From: Chris Moore [REDACTED]
Sent: 20 June 2017 07:33
To: Richard Temple
Subject: RE: AW/137/`7/HH 16 The Fairway, Aldwick

From: Richard Temple [REDACTED]
Sent: 15 June 2017 10:46
To: 'chris@sussexbuildingconsultancy.co.uk' [REDACTED]
Subject: AW/137/7/HH 16 The Fairway, Ald

"The dwelling fronts the southern side of The Fairway, in the Aldwick Bay Conservation Area and it has a strong presence in the streetscene.

PROPOSED GROUND FLOOR PLAN

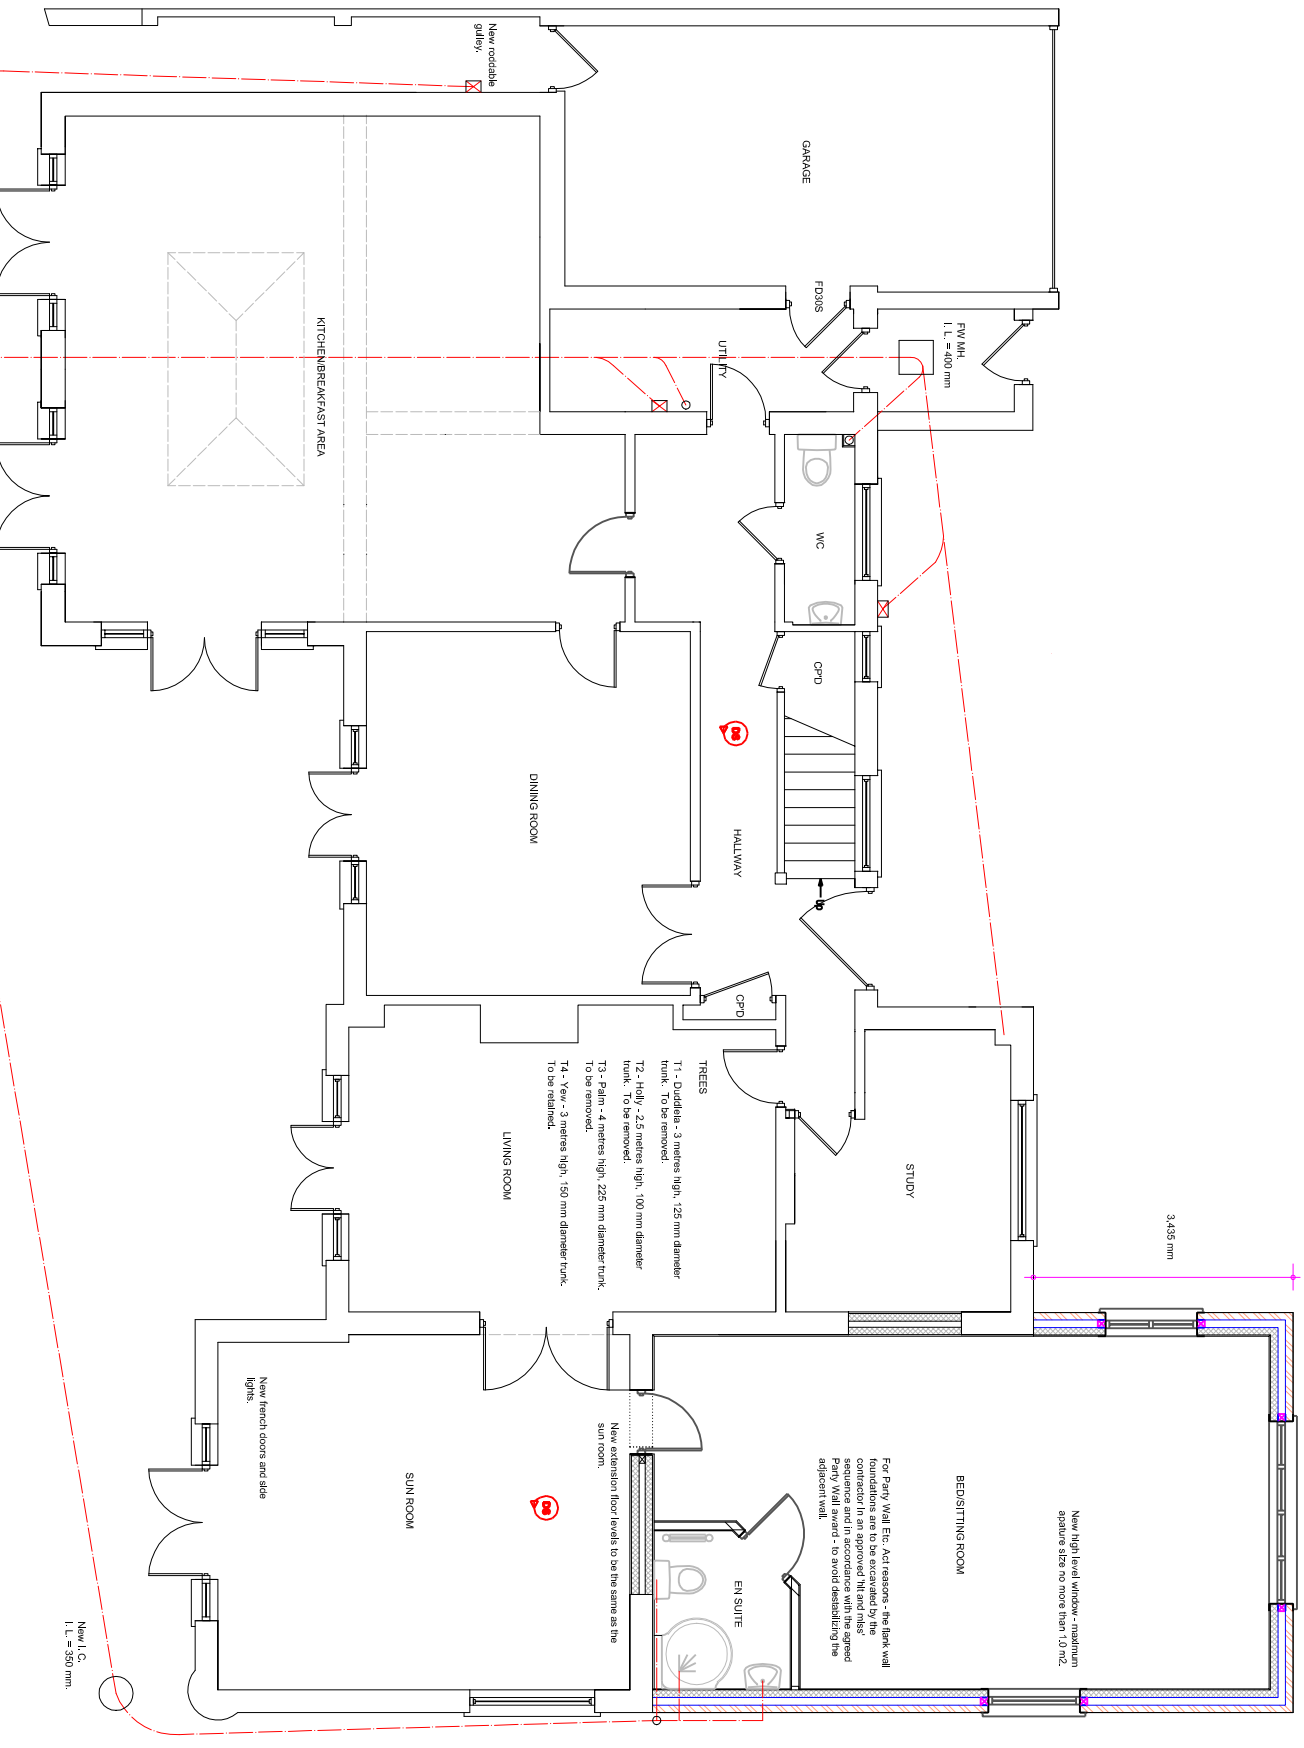
As described above, front additions which diminish the aesthetic of the host building are rarely acceptable. The proposed addition between the dwelling and the garage is a visually intrusive element which clutters the principal elevation of the building and diminishes its distinctive architectural style.

Subject to the omission of the addition between the garage and the dwelling, the proposal will cause no harm to the significance of the conservation area and there is no other objection in terms of Local Plan 2003 Policy Area 2, and Local Plan 2014 Policy HER DM3."

As such, would you be willing to omit the small extension to the garage so we may recommend approval on the application? Or please let me know if you are satisfied for us to recommend refusal so you may appeal the decision.

It is disappointing that there are objections to the very small utility extension when there is implemented planning permission in place for something similar, however, I have spoken to the applicants who have instructed me to delete that part of the proposed development from the application.

Accordingly I attach a copy of revised floor plans, elevations, site, roof and location plans as substitute for those already in your possession.
